**Response to Planning application from Hertfordshire County Council (T and CP GDP Order 2015)**

**District ref:** 6/2018/1225/FULL

58 Plough Hill  
Cuffley  
Potters Bar  
EN6 4DS

Erection of a detached house following demolition of existing including alterations to front drive and garden

Scale	Date
As shown	Nov 2017
Drw No	
DB/JC/201

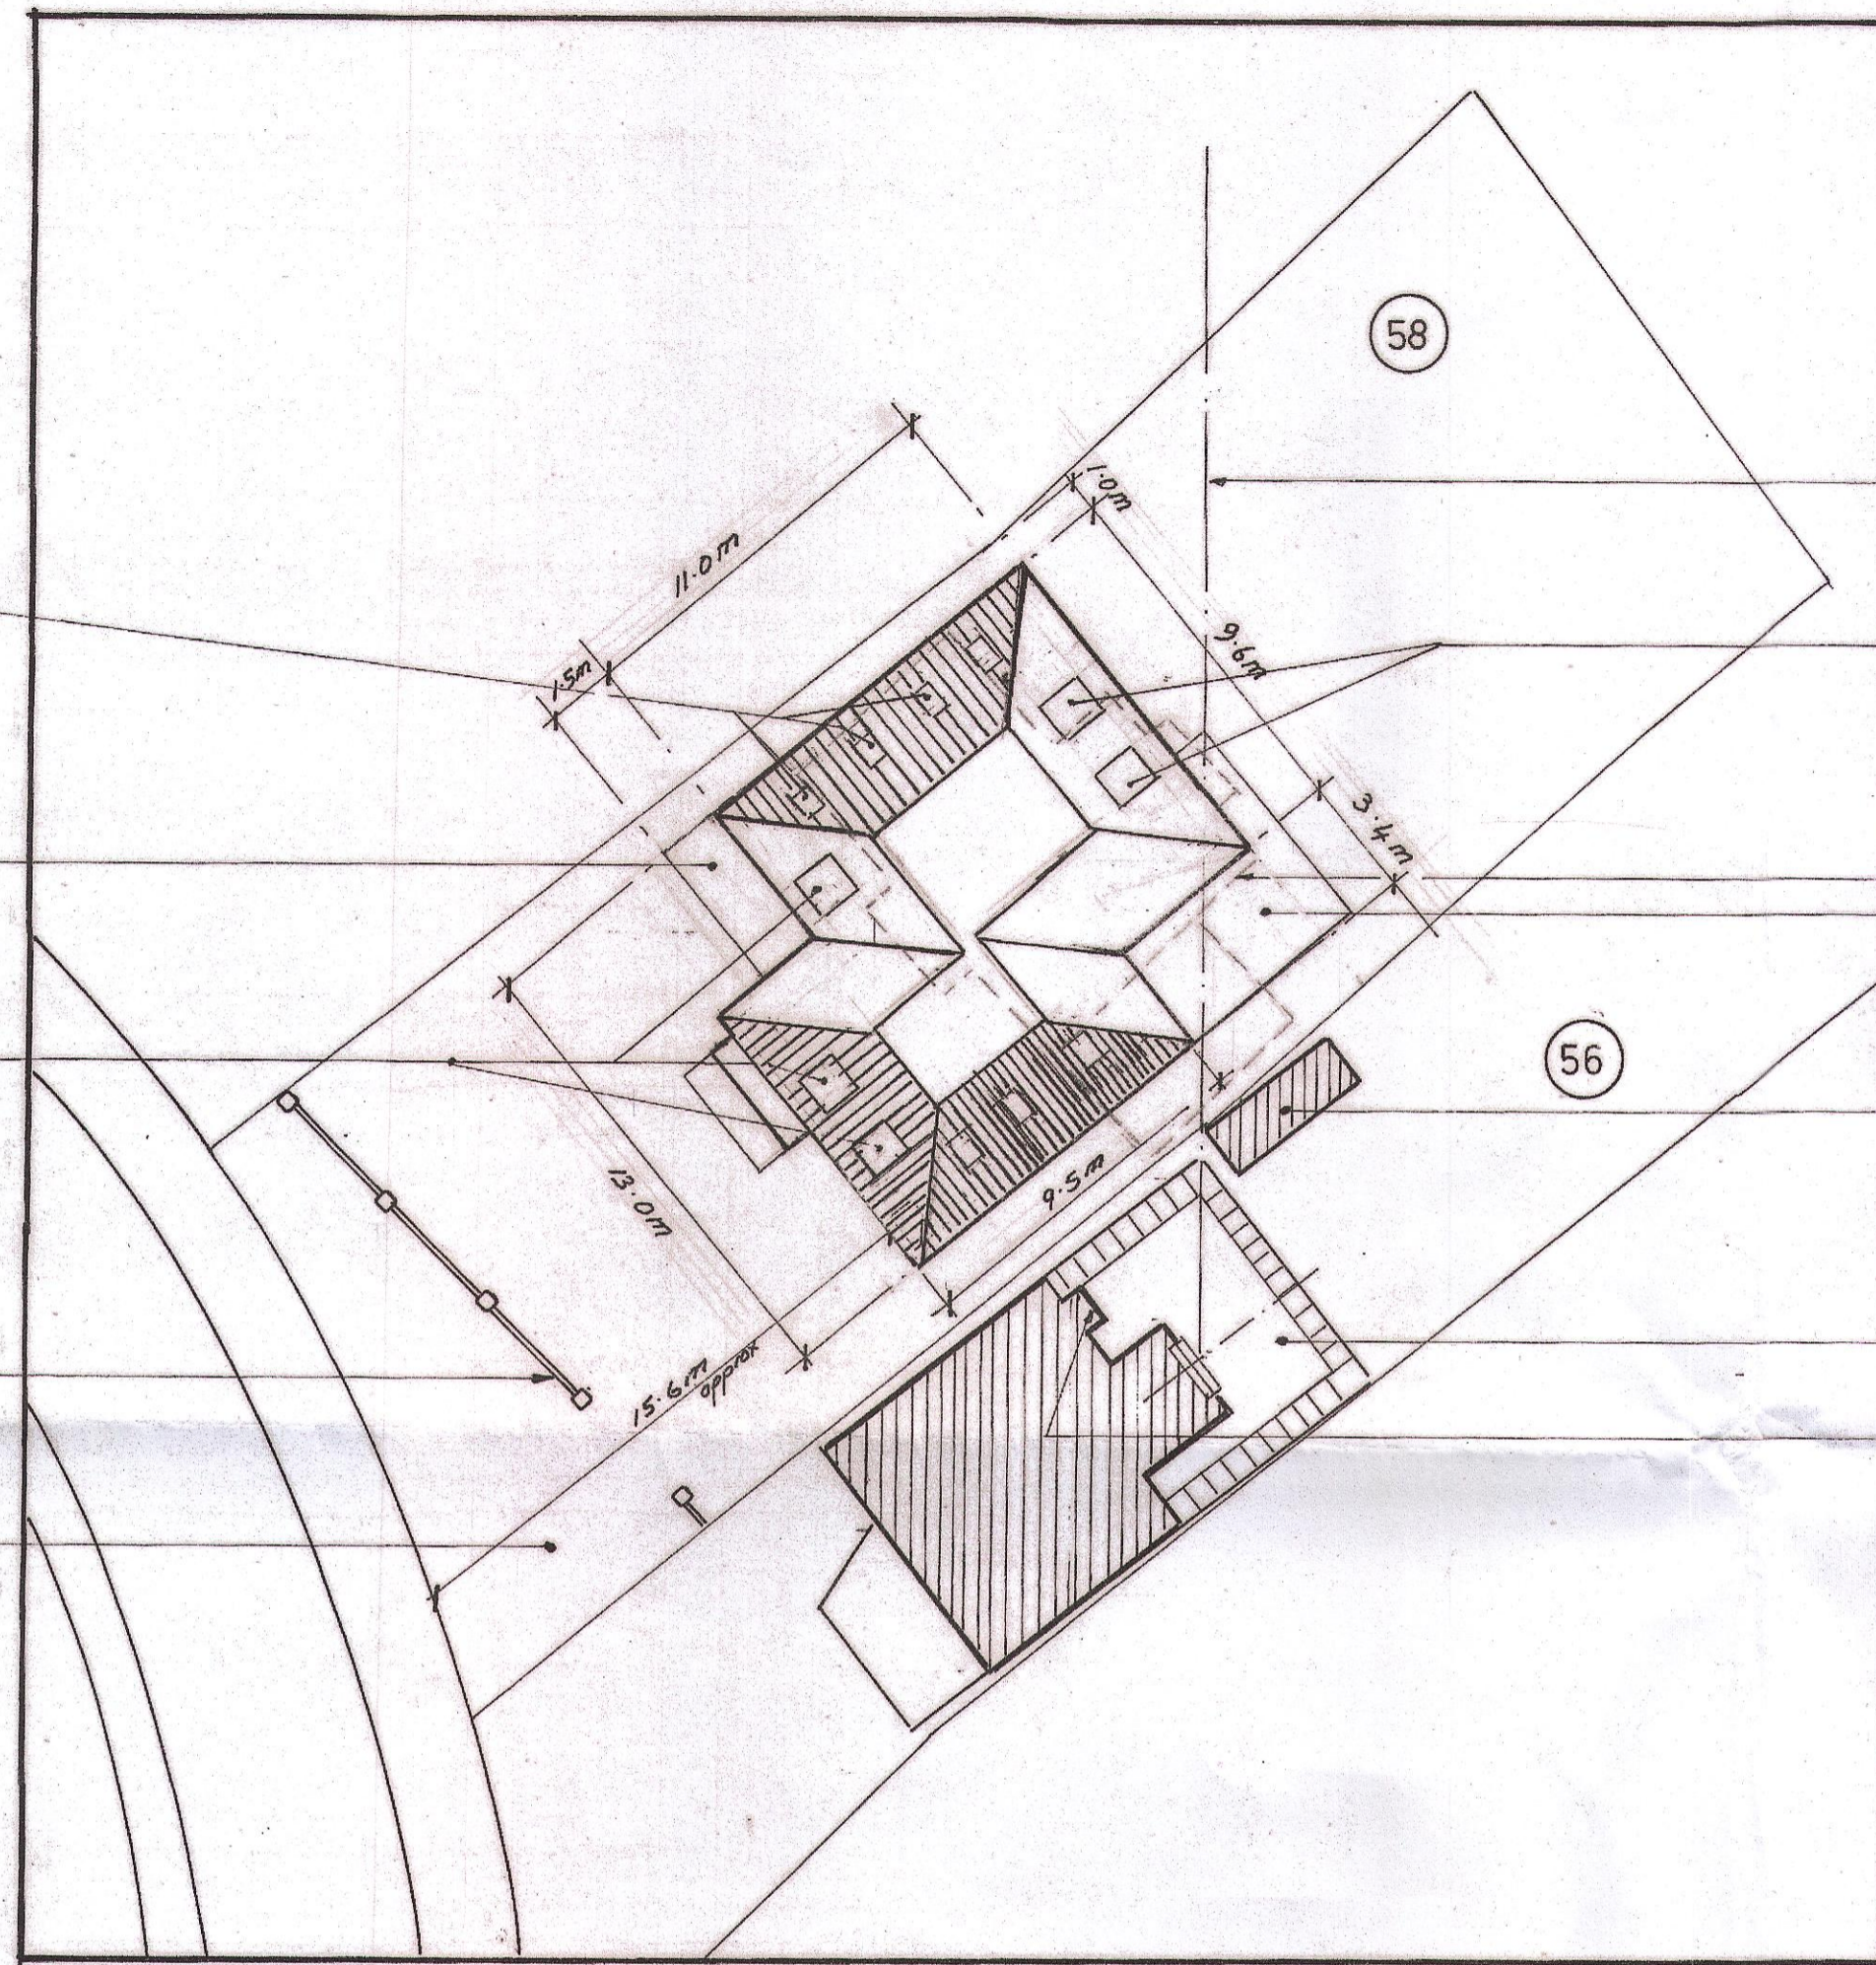
HCC provided comments and recommendations to a previous application at this site, district reference 6/2017/2667/FULL. The current application is, in highway terms, unchanged to that previously considered, with site plan drawing DB/JC/201 A dated Nov 2017 (originally forming the previous application) being resubmitted. It is therefore appropriate for the Highway Authority to repeat its' earlier advice and recommendations.

For the proposed site on Hill Rise, the access is located close to the B157 junction, however the revised VXO is an improvement to the distance from the junction. There are no accidents reported in the previous five years relating to the site or associated access. Visibility is acceptable and the development is unlikely to impact upon highway user intervisibility. As such, the revised access is unlikely to increase any safety concerns with the existing vehicular access.

The application form proposes works to the public highway are required to form a new access, however this is not apparent on the provided plans, with no discernible change between existing and proposed, as such this comment is made on the understanding that no works are required.
